STATE OF NORTH CAROLINA
DEPARTMENT OF TRANSPORTATION

June 13, 2012

Subject: **REQUEST FOR THE LIFTING OF "ON HOLD STATUS"** for the Section 401 Water Quality Certification for the proposed replacement of Bridge No. 118 over Lanes Creek on SR 1937 (Old Pageland Marshville Road) in Union County, Federal Aid Project No. BRZ-1937(2); Division 10; TIP No. B-4652; WBS 33818.1.1.

Reference: NCDOT Permit Application for a 404 Permit and 401 Water Quality Certification dated April 13, 2012.
NCDWQ on hold letter notification dated May 30, 2012.

STATE OF NORTH CAROLINA
 DEPARTMENT OF TRANSPORTATION
 RALEIGH
GENERAL DRAWING
 BRIDGE OVER LANES CREEK
 ON SR 1937
 (OLD PAGELAND-MARSHVILLE RD.)
 BETWEEN
 SR 1915 AND SR 1941

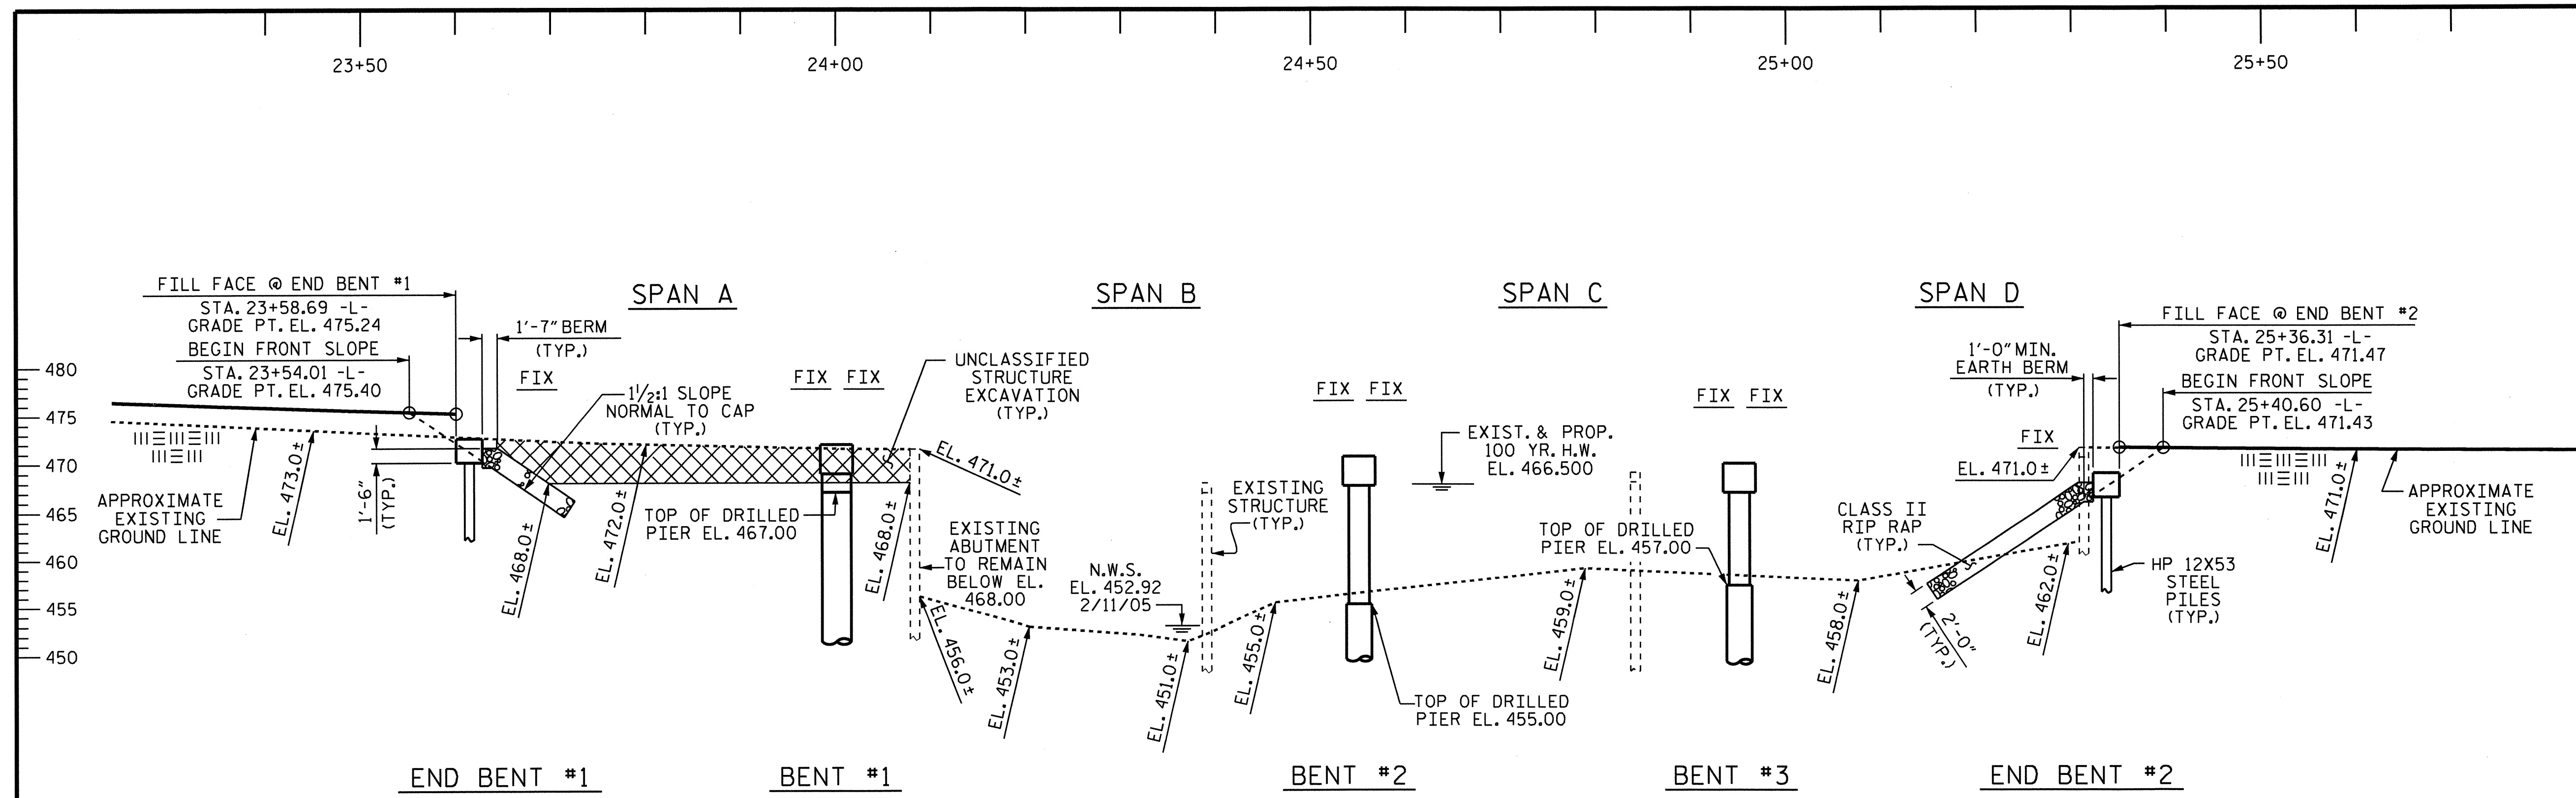
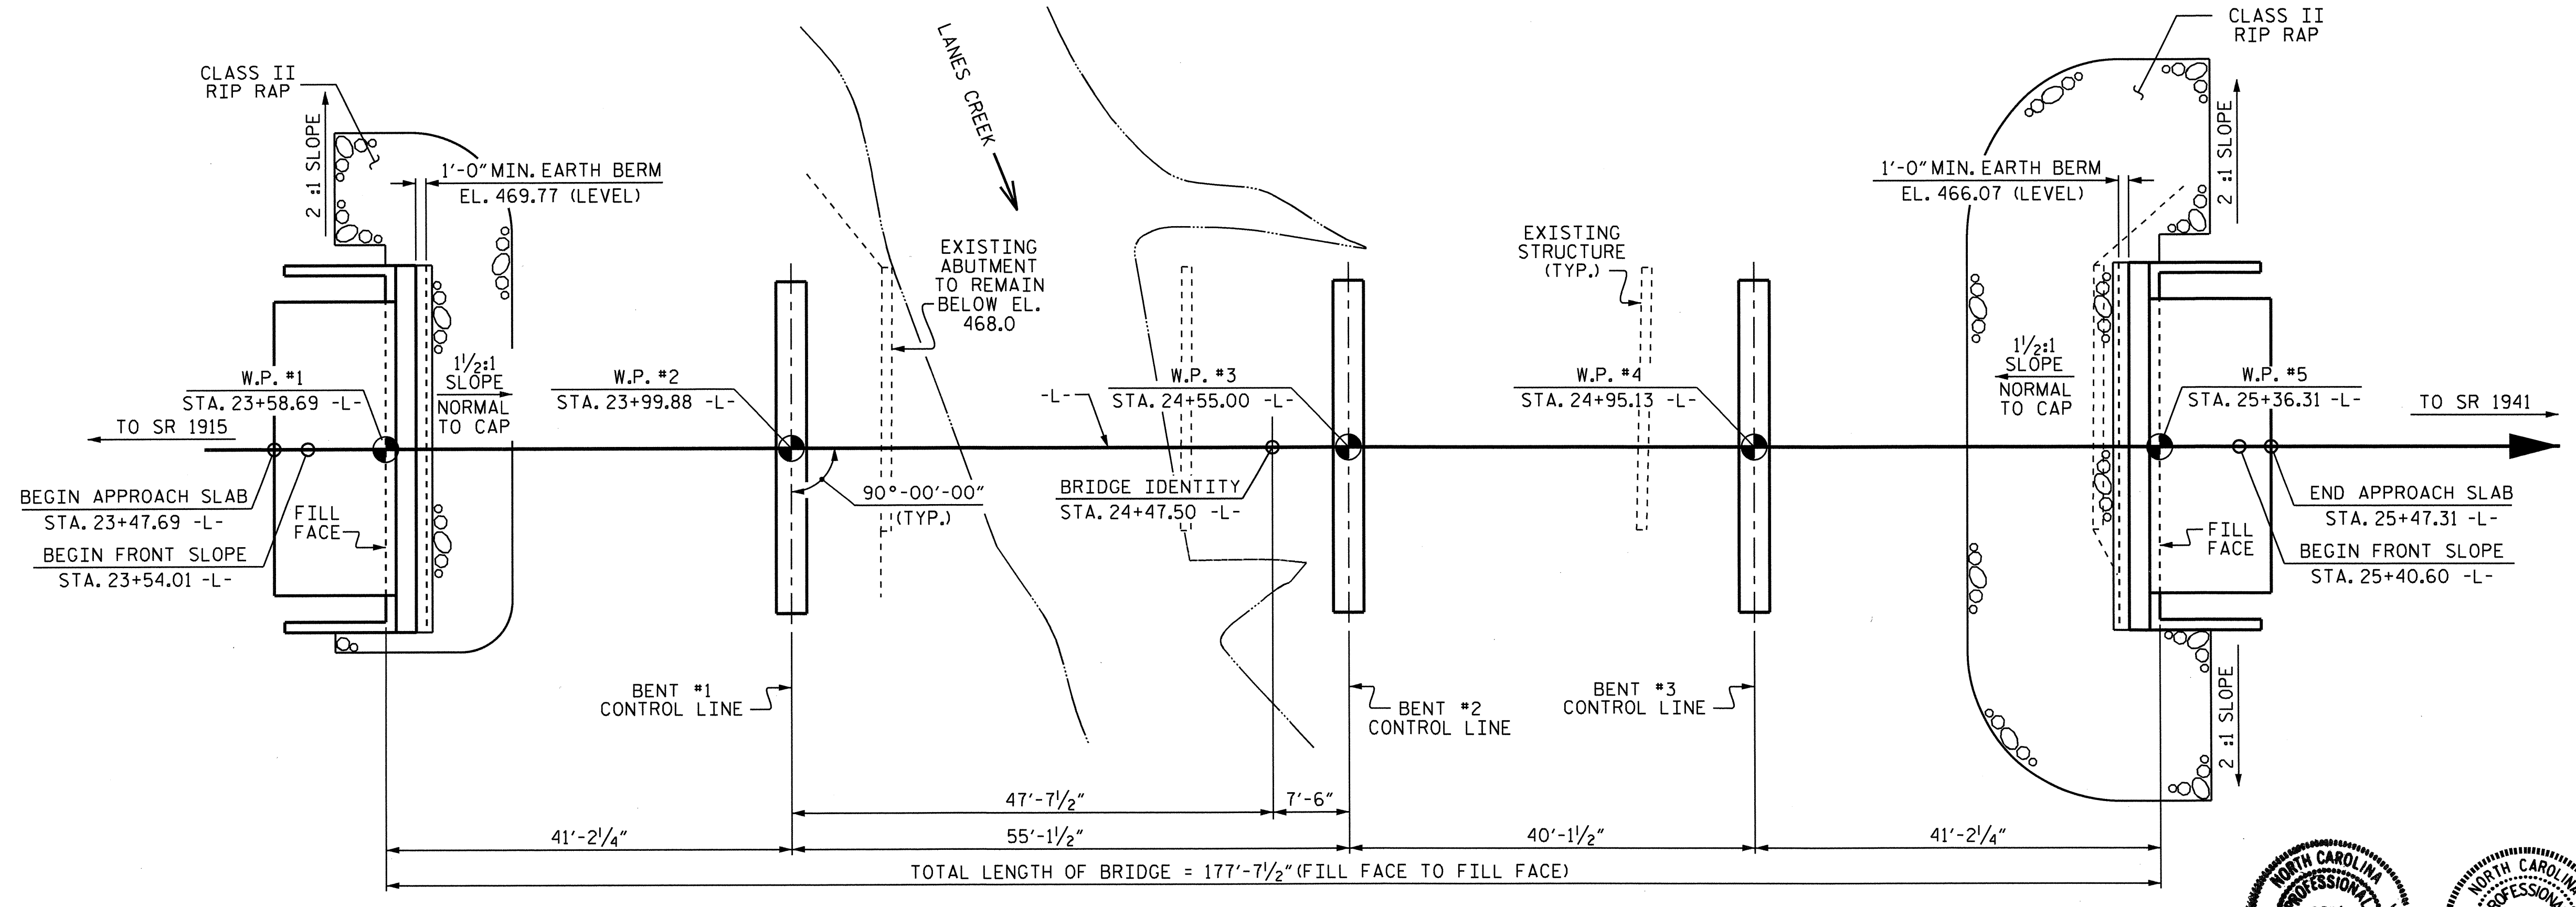
"A site visit indicates that the streambank for the proposed slope reinforcement appears to be fairly stable (including trees). It is unclear why this activity is necessary as the new bridge will be longer and provide additional floodplain availability for the stream. Additional floodplain availability will allow for energy dissipation on the floodplain rather than the streambanks. Provide information to support the request for the proposed 74 linear feet of stream impact. Additionally, if the need for the impact can be supported, DWQ does not typically authorize stabilization using gabions and would prefer a more natural method of streambank stabilization. Please provide an alternative form of stream bank stabilization."

In the bridge profile view, also depicted in Figure 1, shows that despite having a longer proposed structure, it does not provide any additional significant flow area in the floodplain than the existing bridge. The excavation (hatching) shown on the left (right upstream bank-yellow arrow) has been done to provide minimal area for future structure inspections and not increased floodplain flow. The design year and 100 year flood events do not even reach this excavated area. The attached plan sheet with contours (Figure 3) may help display a clearer picture of the situation.
